**KIRKLEES METROPOLITAN COUNCIL
INVESTMENT & REGENERATION SERVICE**

**DELEGATED DECISION TO DETERMINE APPLICATIONS FOR
NON-MATERIAL AMENDMENTS**

Reference No: **2026/NM/90780/W**

Description: Non material amendment to previous permission
2025/93073 for erection of first floor side extension,
hip to gable, dormer and associated works

PROPOSED 1ST FLOOR PLAN

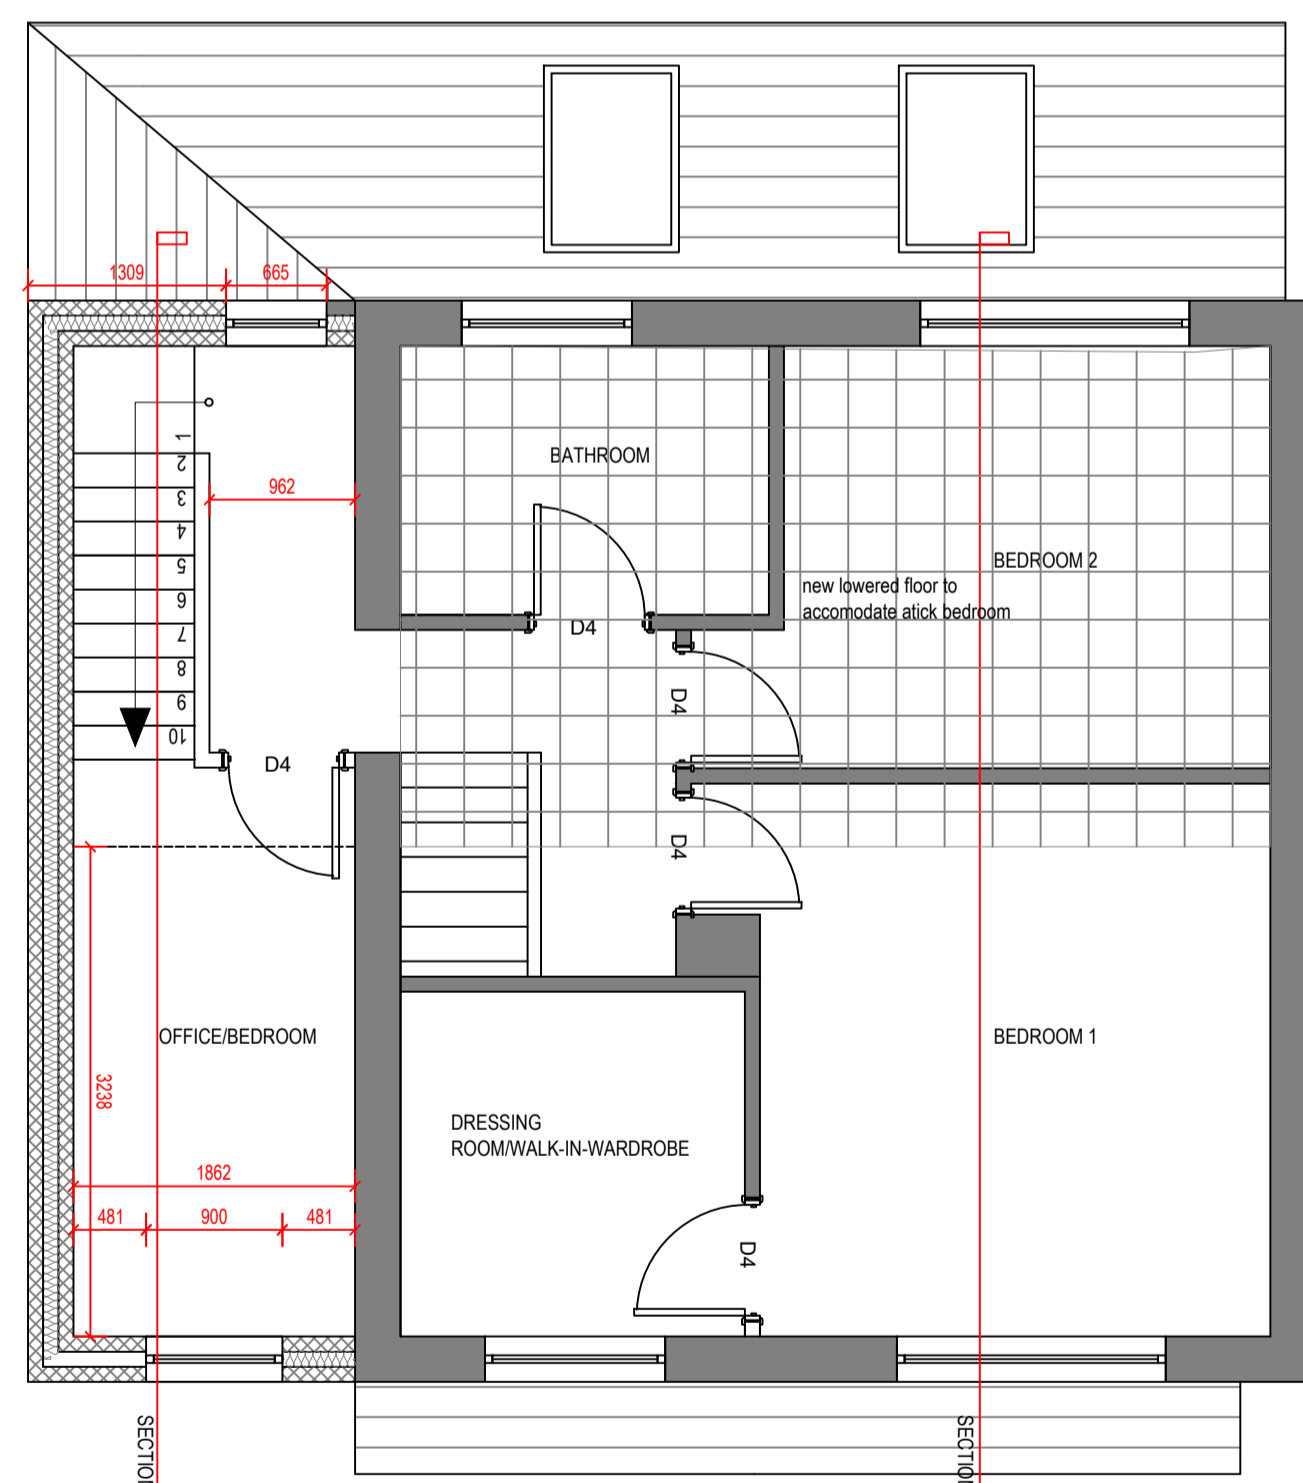
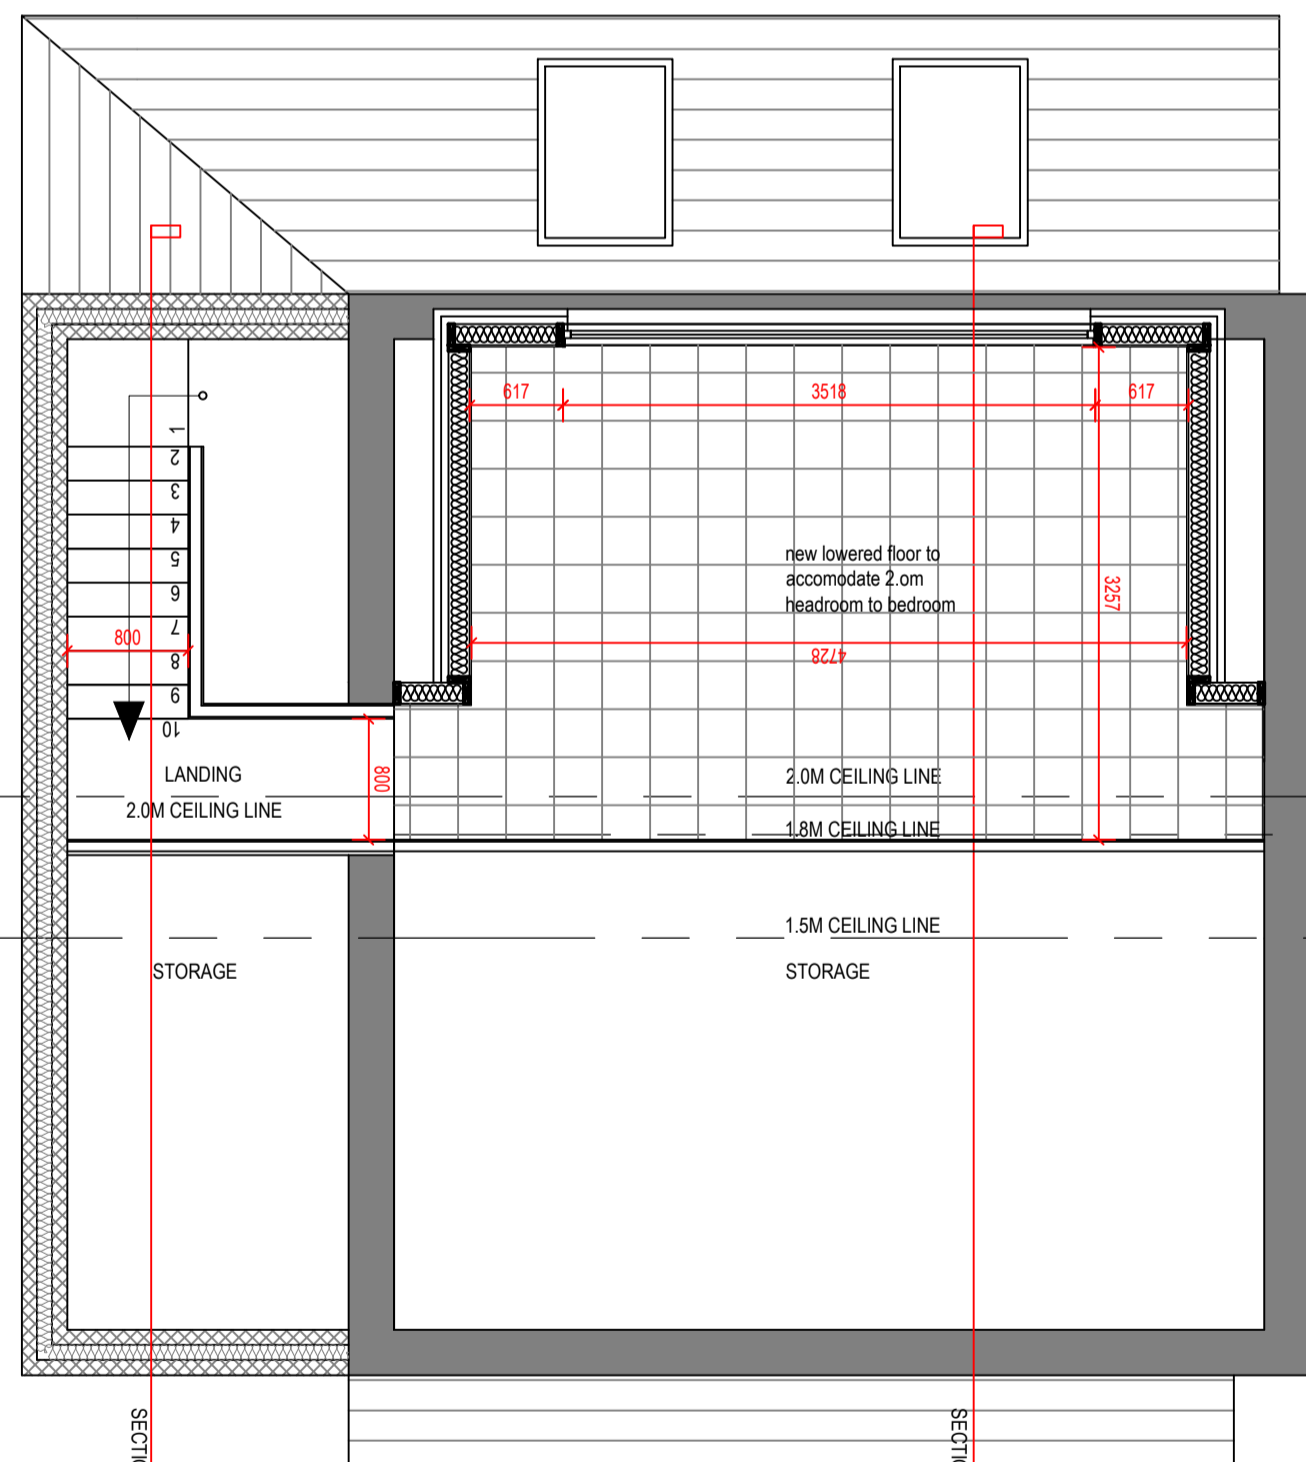
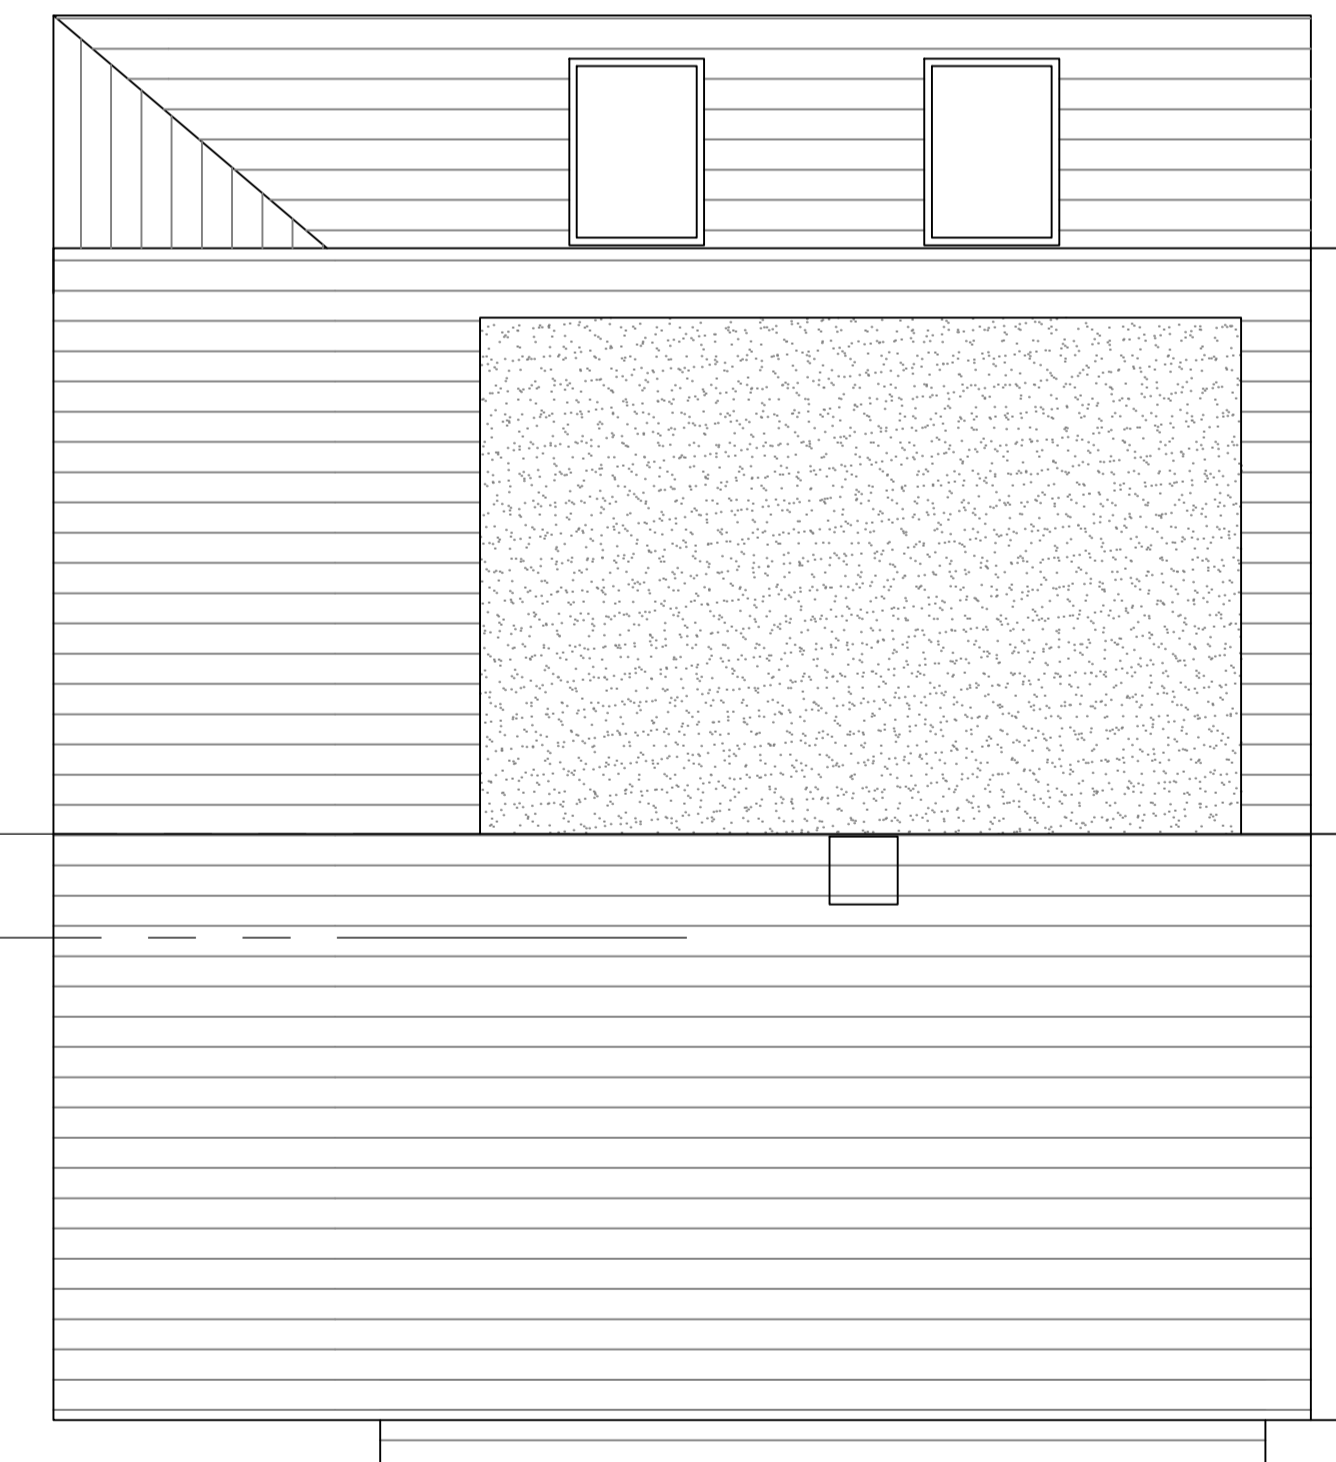
In relation to the original approval, the approved first floor side extension was approved due to its compliance with the Councils House Extensions and Alterations SPD. The proposed amendment would result in the extension being contrary to the House Extensions and Alterations SPD for first floor side extensions. Furthermore, this addition would not allow a visual break from the original dwelling thereby not appearing subservient to the host, causing the property to appear unusually enlarged and unsympathetic in the context of the street scene.

The inclusion of the hipped to gable and dormer extension cannot be considered as inconsequential to the original approval.

As aforementioned, the proposed amendments would result in extensions that would not appear subservient and therefore unsympathetic in the context of the street scene.

Due to the inclusion of the rear dormer, the interest of a third party or body who participated in or were informed of the original decision would be disadvantaged.

The amendments shown on drawing No. '2025-011-(20)002 Rev_A' are not considered appropriate to be regarded as a non-material amendment to the previous planning approval 2025/93073.
